Cornwall Council
Planning Department
New County Hall
Truro

22 January 2021

Objection Letter – Planning References: PA20/10880 and PA20/10882
Proposal – Provision of new dwellings on plots 1 and 2
Site - Land East Of Springfield Road From Tanner Rock To Sunset Strip Rejerrah TR8
5QA

*Proposed Plot 1 Layouts  
Red Line Plot 1*

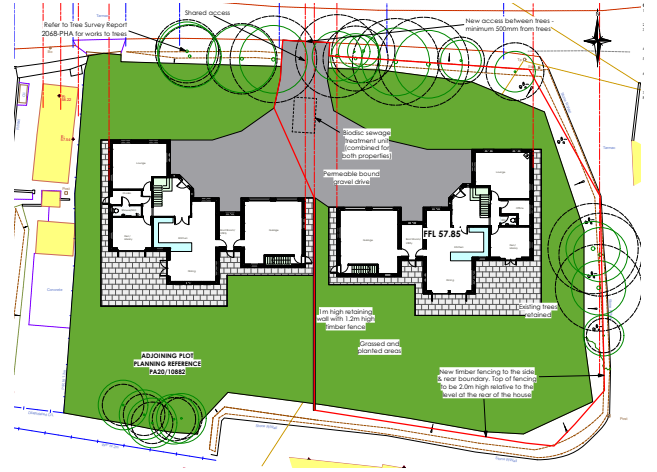
The proposed plans highlight that the proposal would also result in the introduction of windows at ground floor and at first floor level that would directly overlook the private amenity space, as well as habitable room windows of the rear of my client's property, as well as that of neighbouring properties. The level of fenestration facing my client's property as well as neighbours would demonstrably harm their enjoyment of their dwellinghouse and private areas, as they would be constantly overlooked.

As a result of the proximity of the development and its intended overall, size, scale, mass and poor design it will appear as an imposing and obtrusive structure from my client's property that will clearly have an unacceptable overbearing impact. The harm will also be compounded as due to the trajectory of the sun the development will cast permanent shadows on their property as well as lead
